September 10, 2023
Project No. T-8718

Subject: Response to City of Mercer Island Comments
3036 – 67th Avenue SE
Mercer Island, Washington

References: 1. Geotechnical Report, 3036 – 67th Avenue SE, Mercer Island, Washington, Project No. T-8718, prepared by Terra Associates, Inc., dated August 22, 2022, revised April 21, 2023
3. Geotechnical Peer Review Comments, prepared by City of Mercer Island, dated August 2023

TEMPORARY GRADING PLAN
3036 67TH AVENUE SE
SITE PLAN
PARCEL 2174501025
CITY OF MERCER ISLAND WASHINGTON

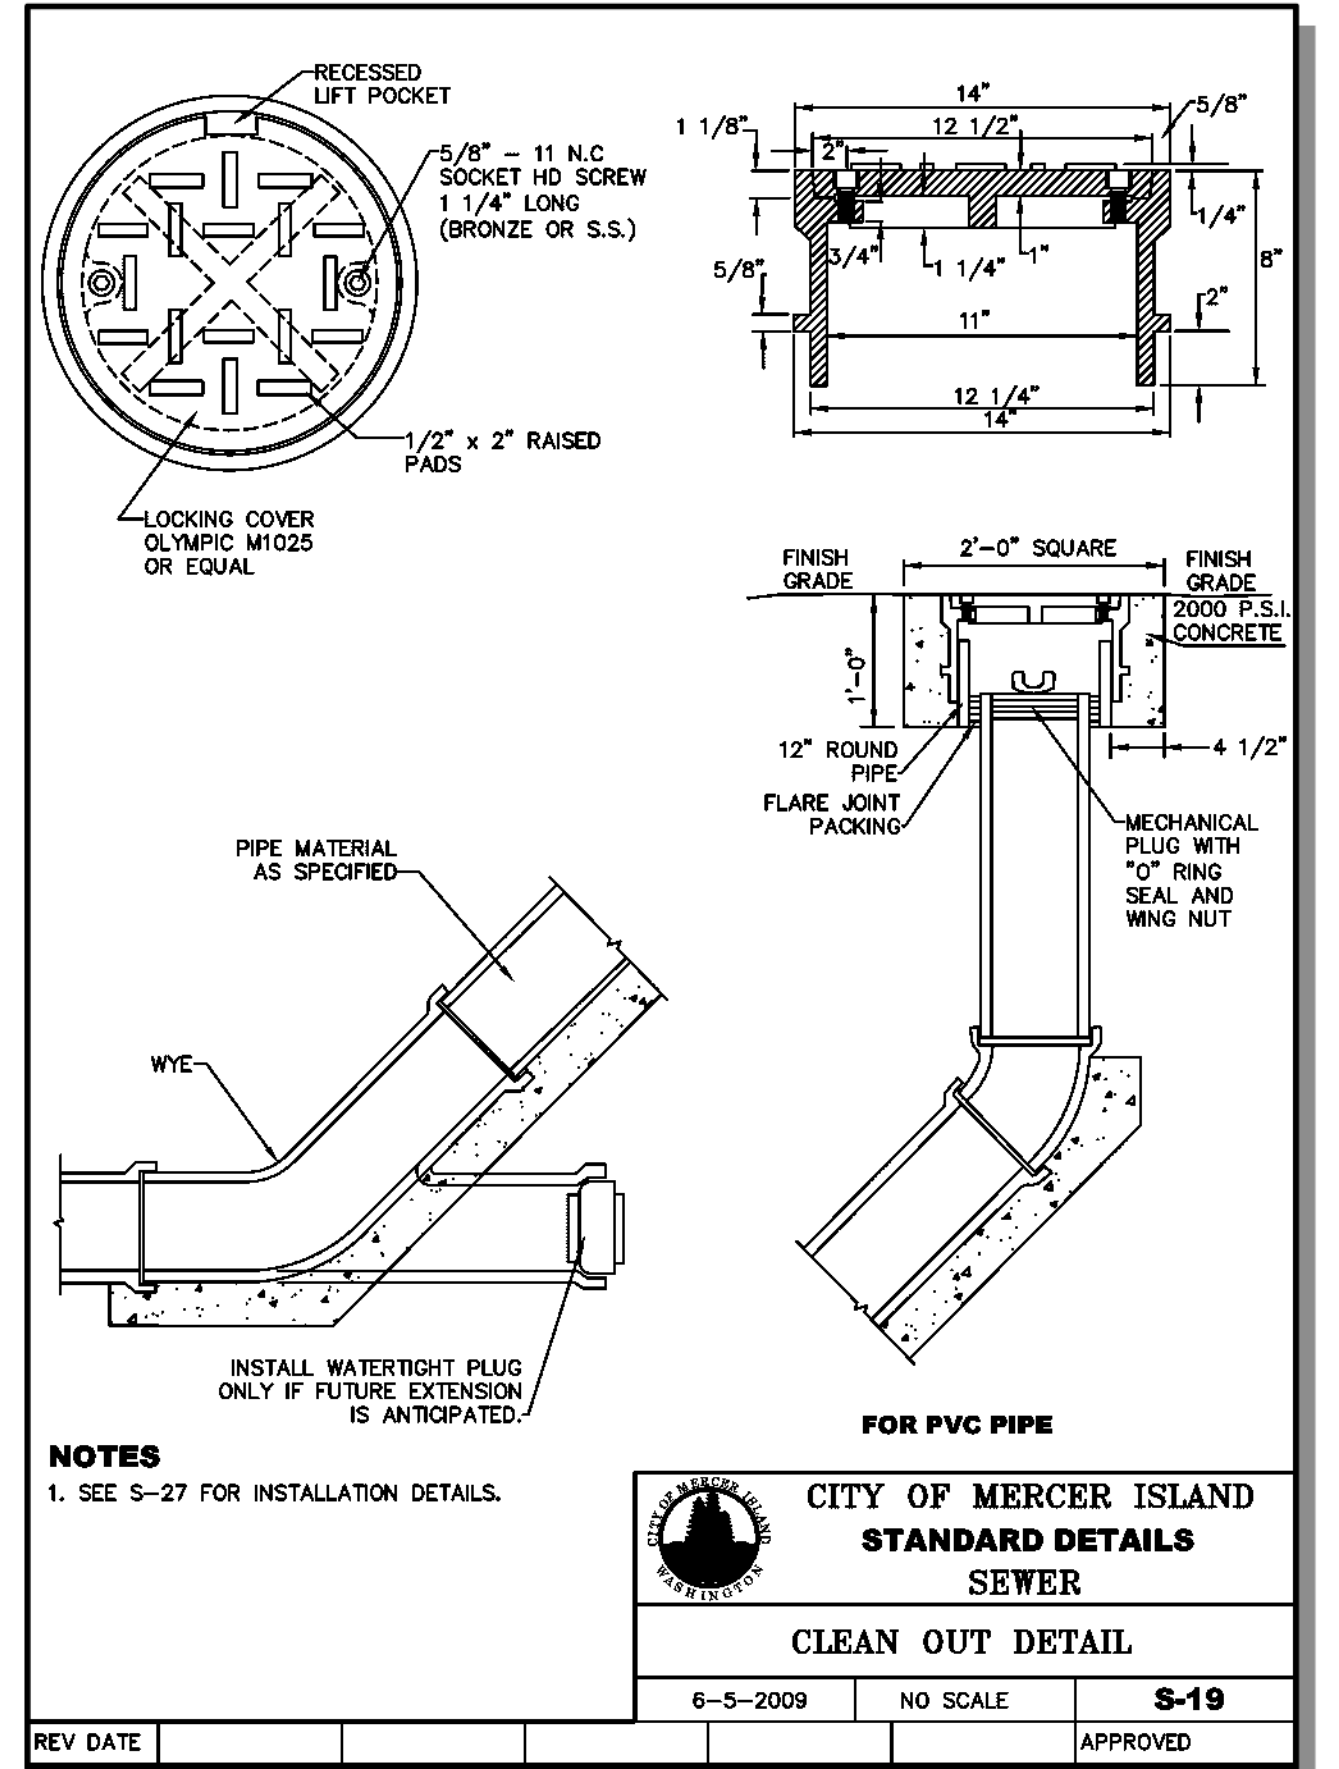
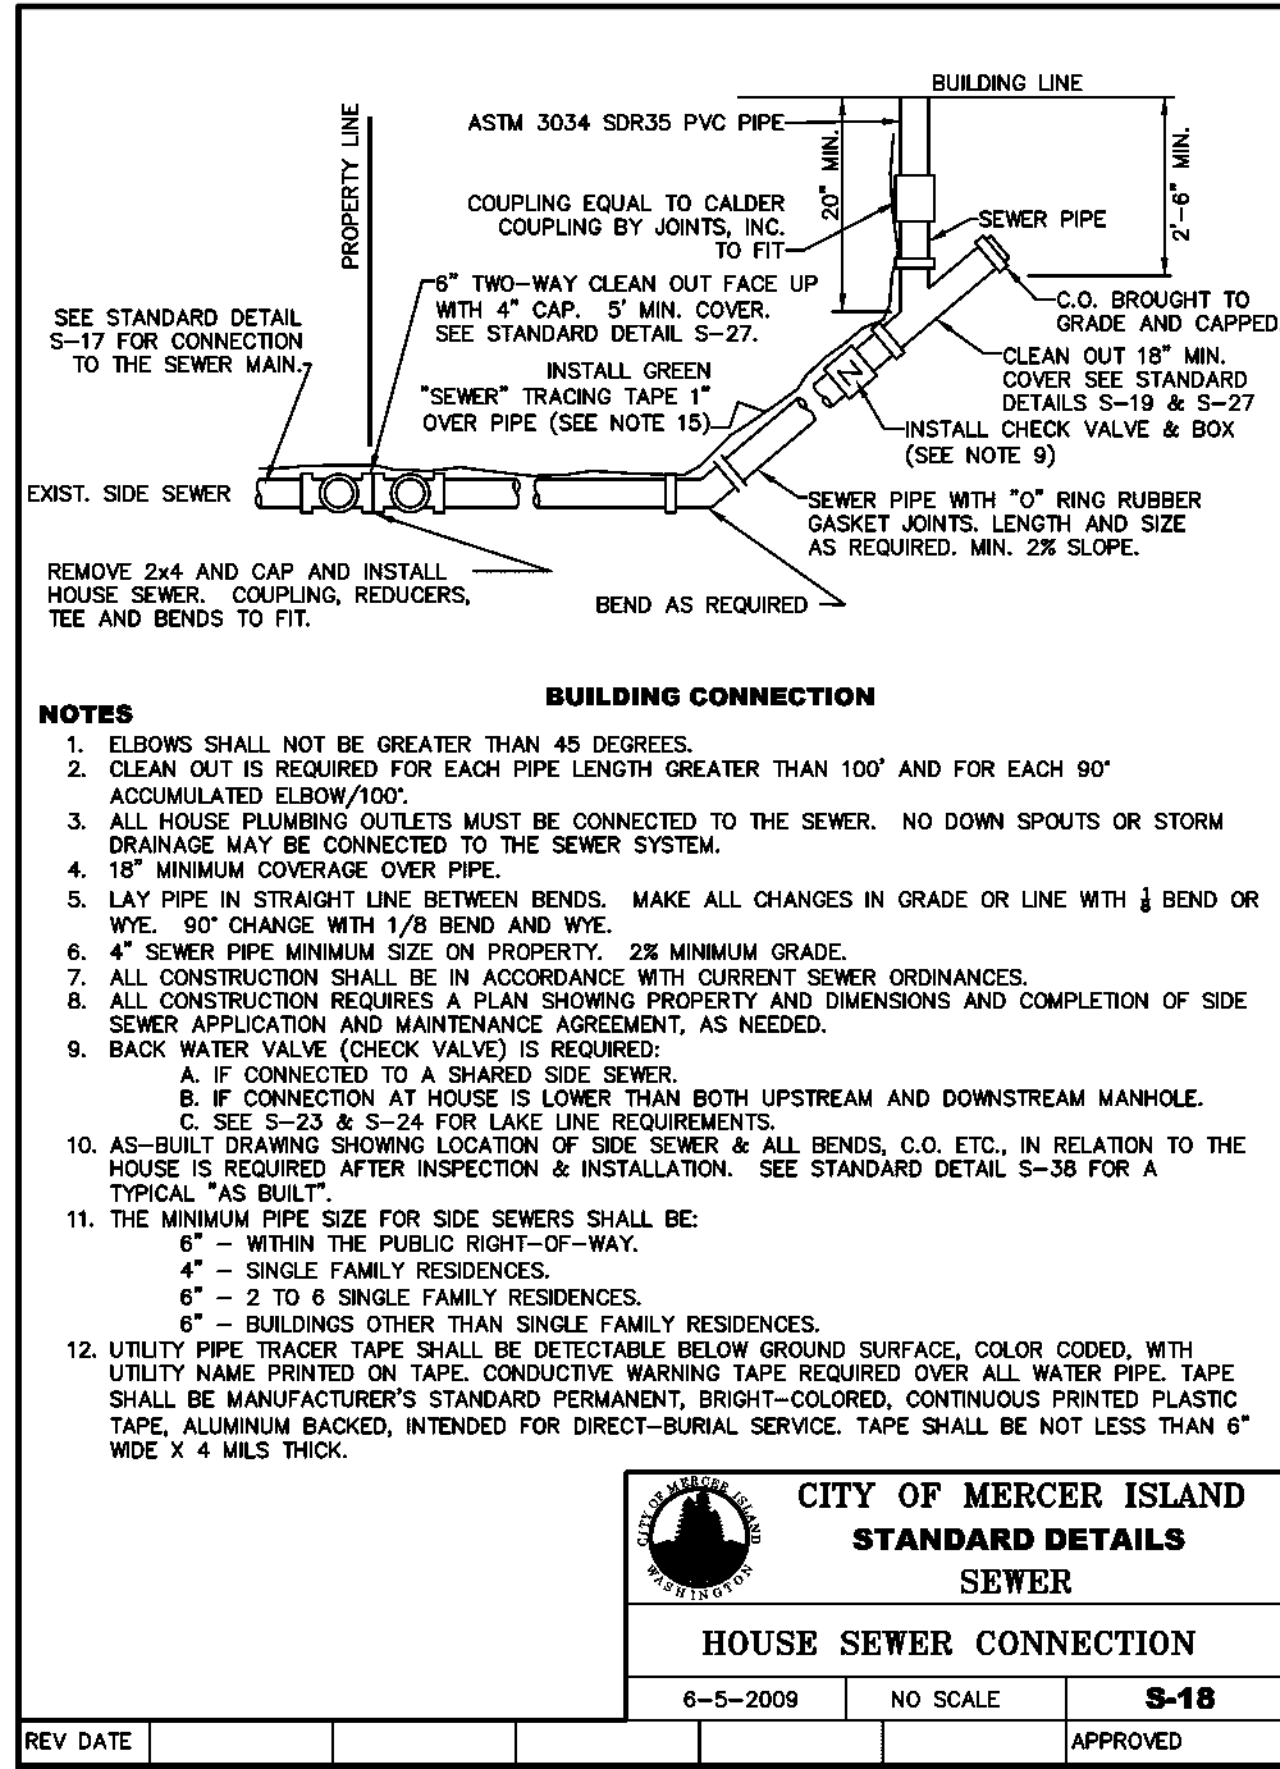
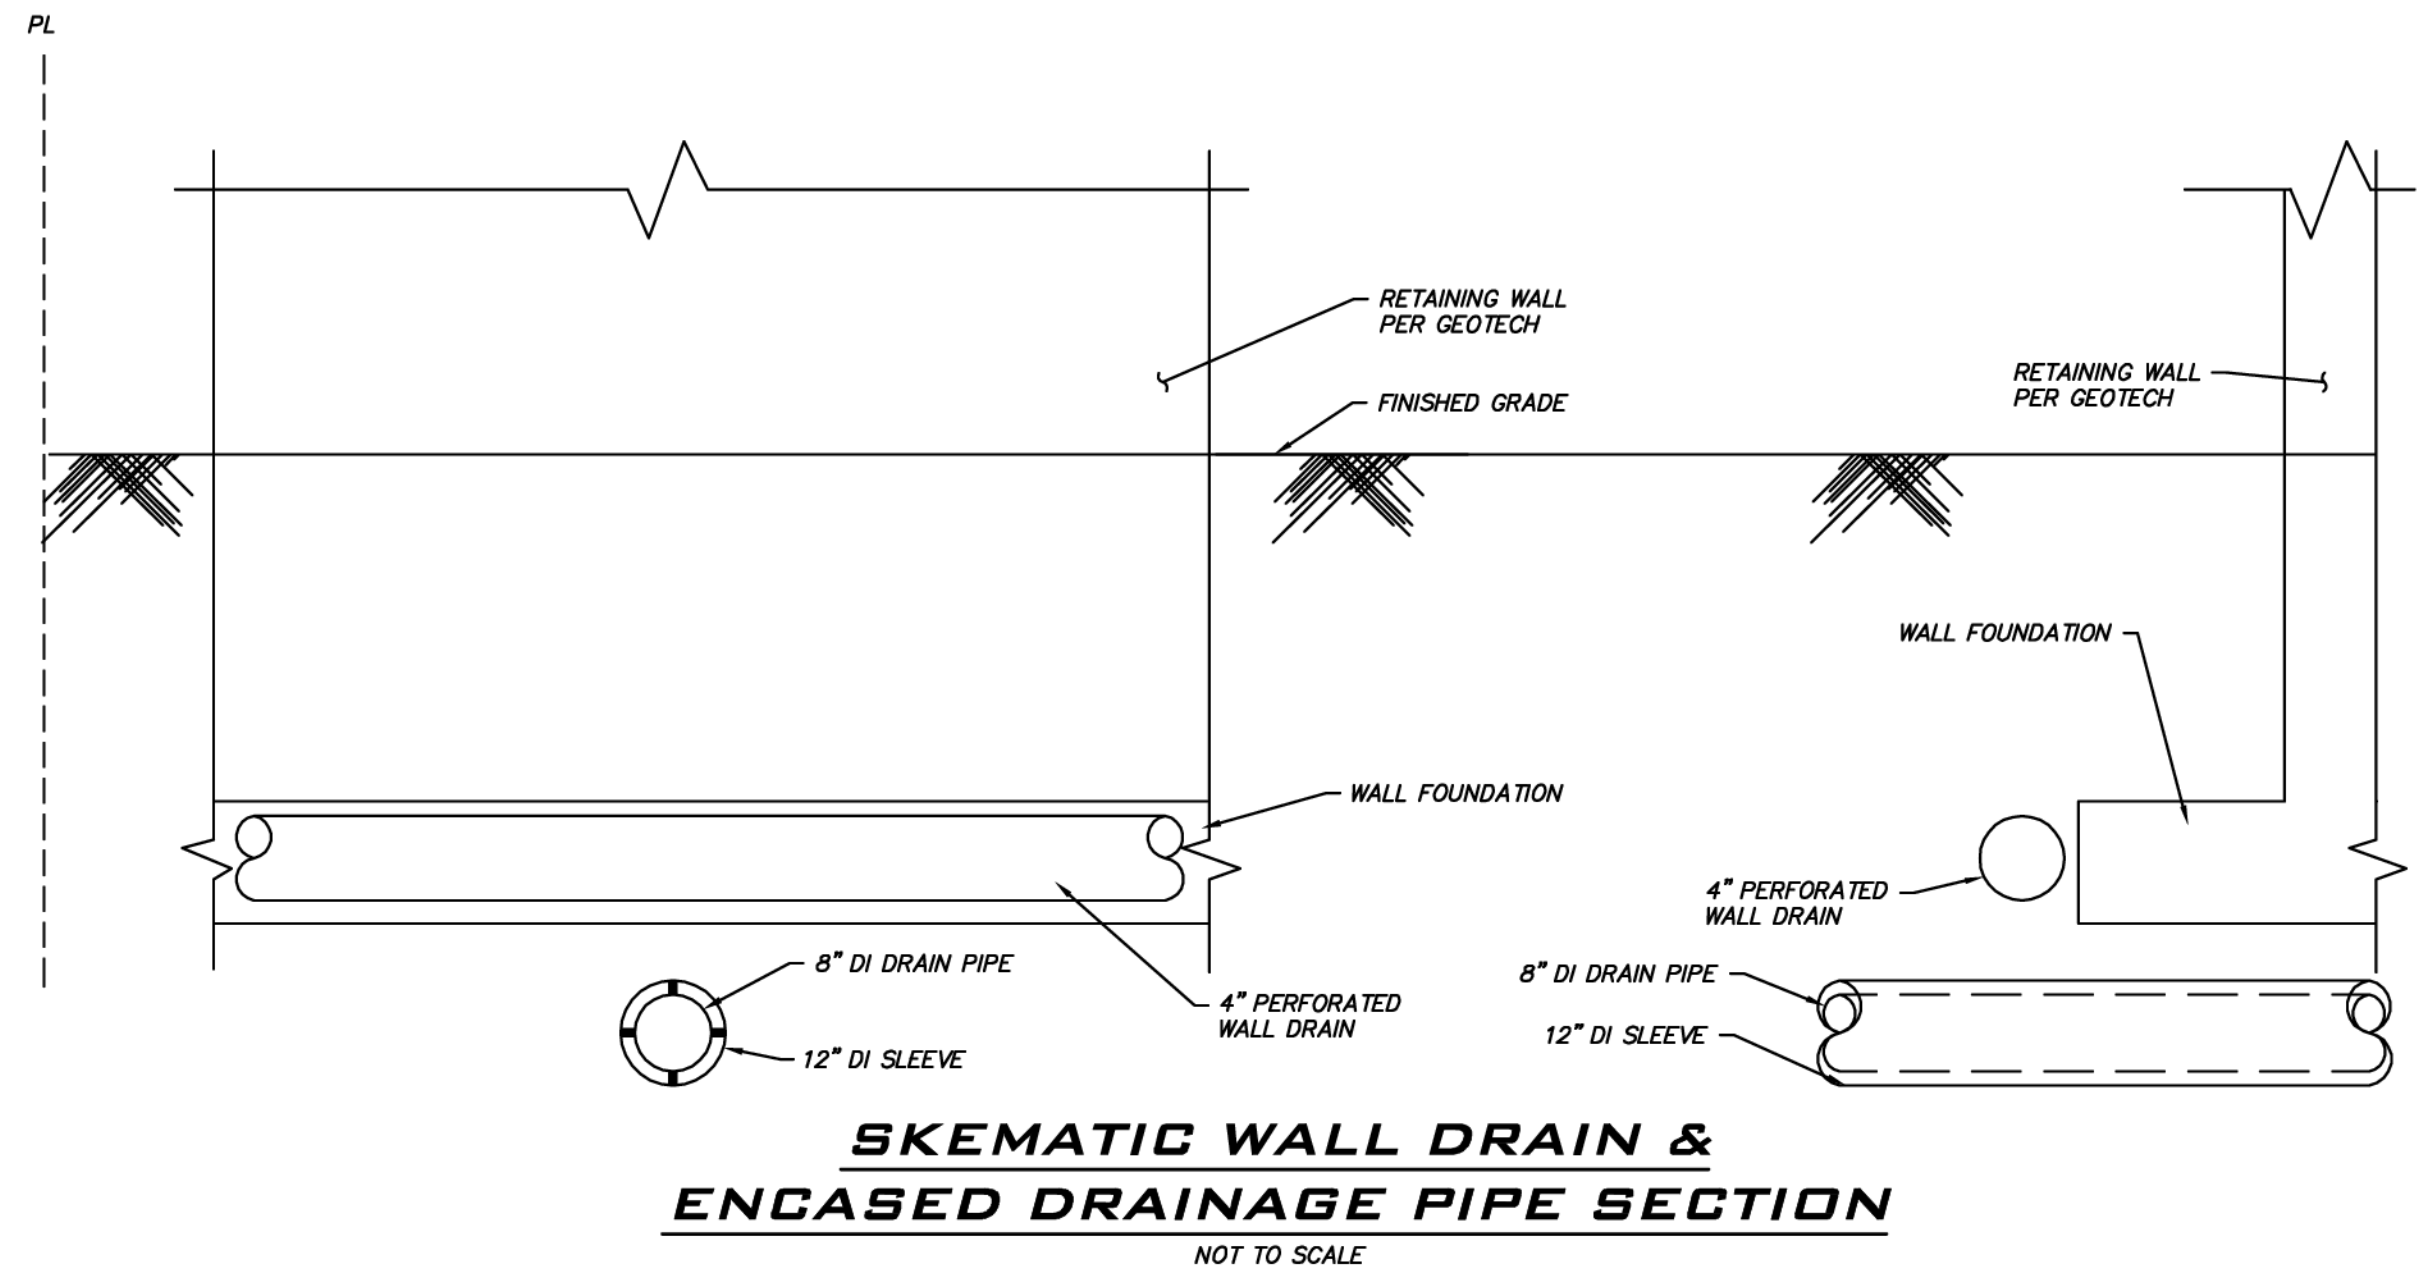
Please revise the project plans (e.g. temporary grading plans, depth of interceptor trench, etc.) and revise stability analyses to include the potential overexcavation depths required to remove the loose soils below the foundations.

The stability analysis has been updated to include the potential over excavation.
